Application No: BN/26/22/PL
Site Address: Land East of Eastmere House Eastergate Lane Eastergate PO20 3SJ
Description of Works: Construction of 1 No. two storey detached dwelling house on existing paddock. This application is a Departure from the Development Plan and is in CIL Zone 3 and is CIL Liable as new dwelling.

Environment Officer
Environmental Protection
Chichester District Council

Elevations & Plans as Proposed

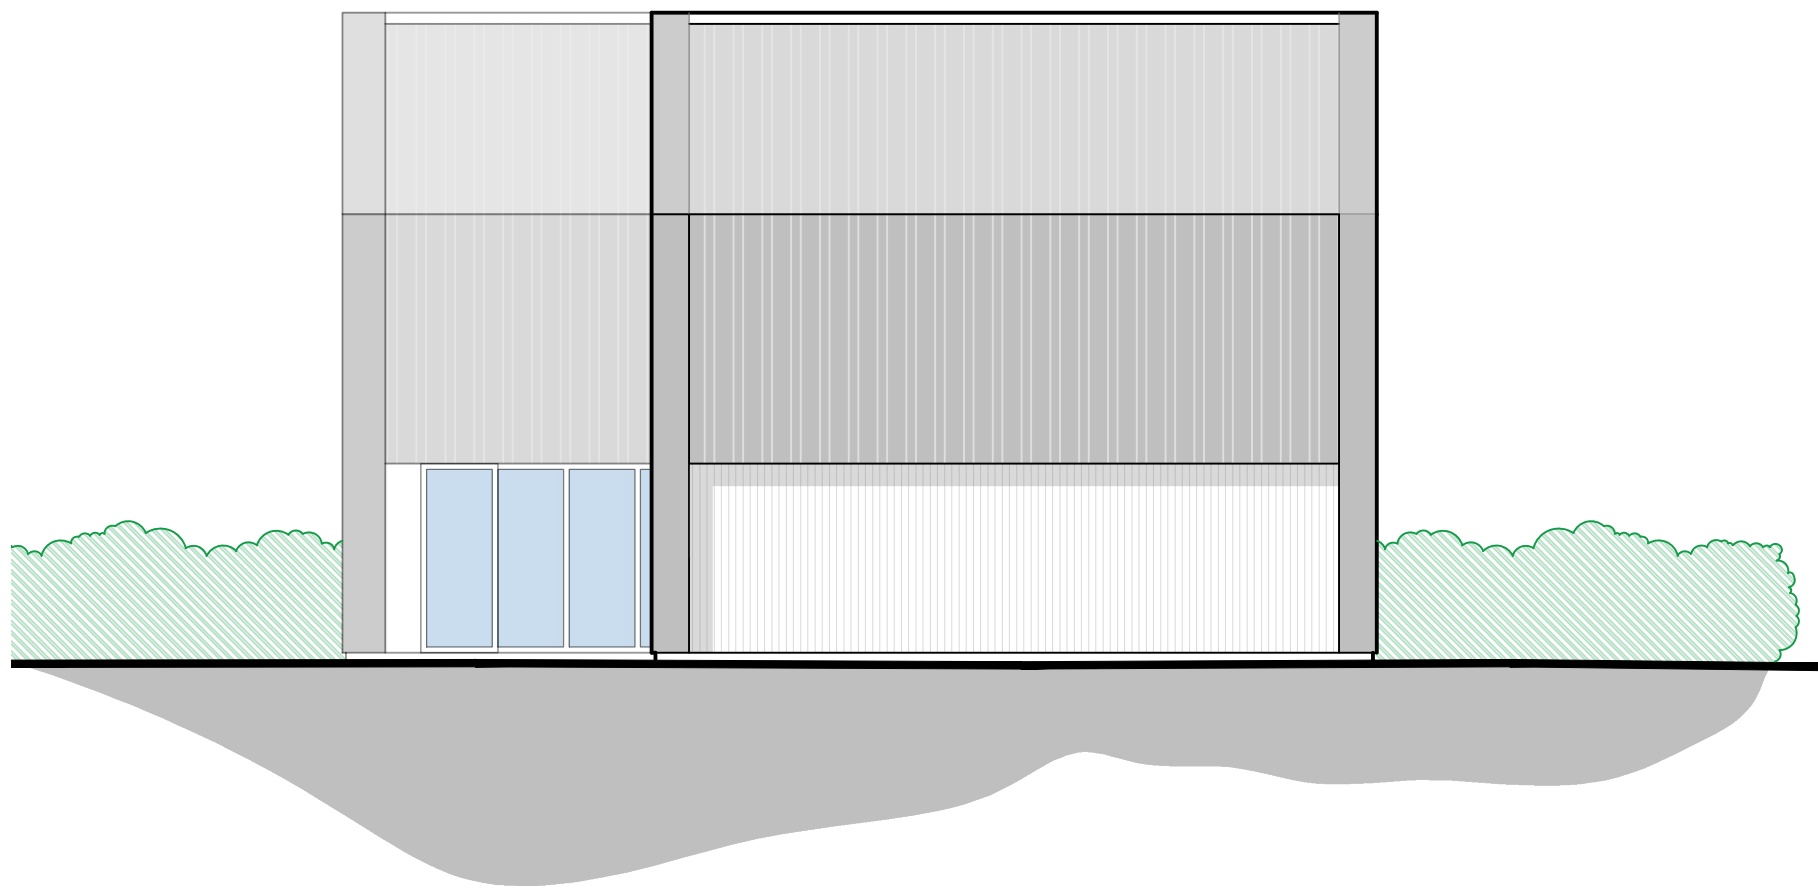
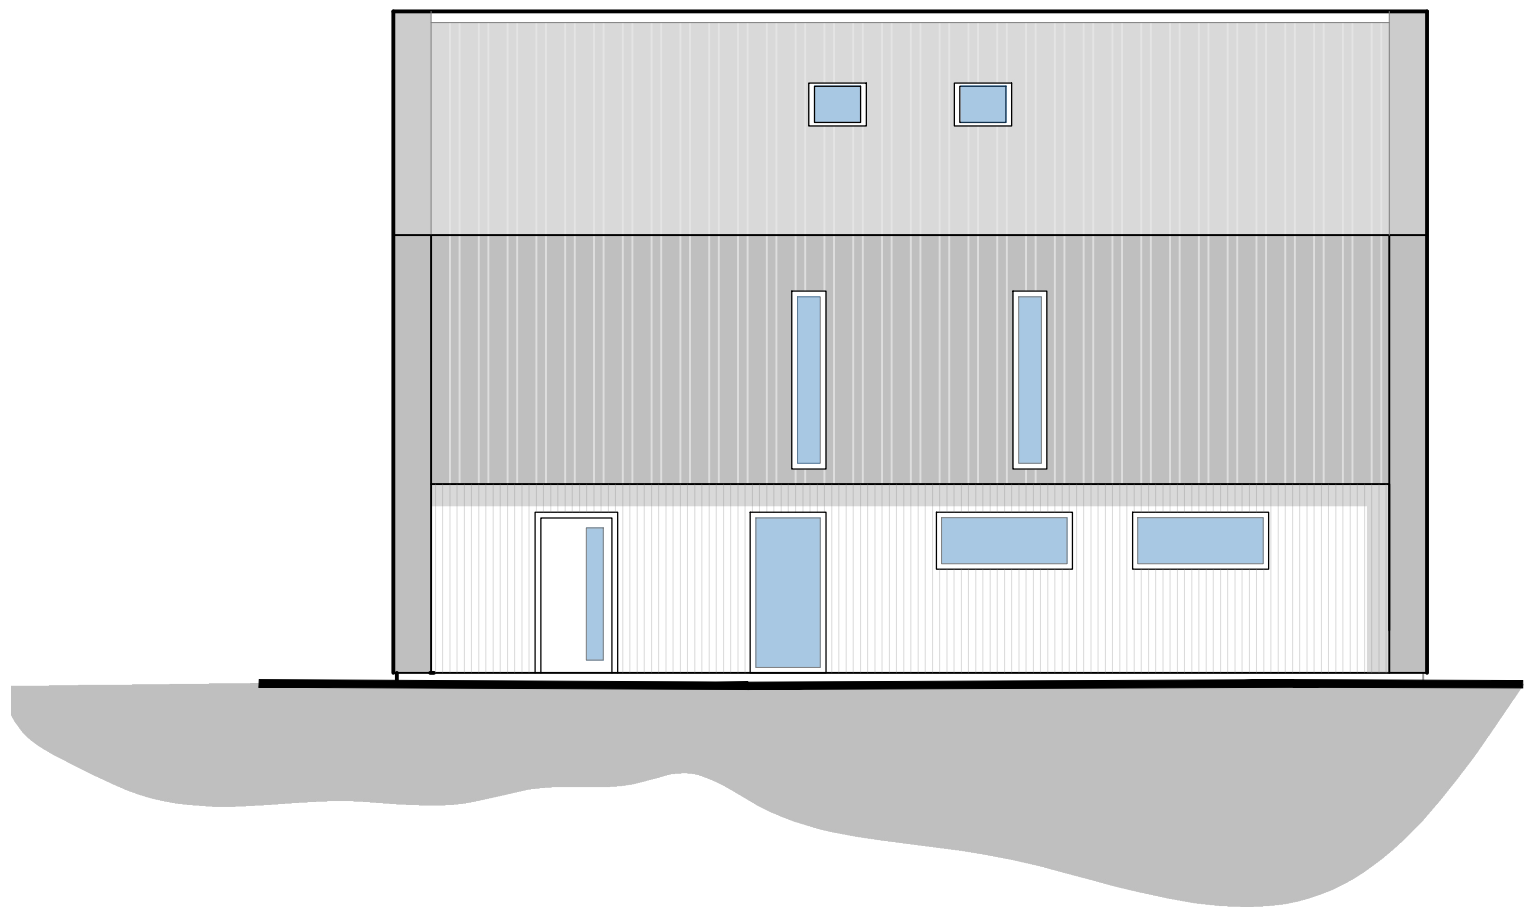
We require that a bat box is installed on the buildings onsite facing south/south westerly positioned 3-5m above ground.

The lighting scheme for the site will need to take into consideration the presence of bats in the local area and the scheme should minimise potential impacts to any bats using the trees, hedgerows and buildings by avoiding unnecessary artificial light spill through the use of directional light sources and shielding.

We would like a bird box to be installed on the building / and or tree within the garden of the property.
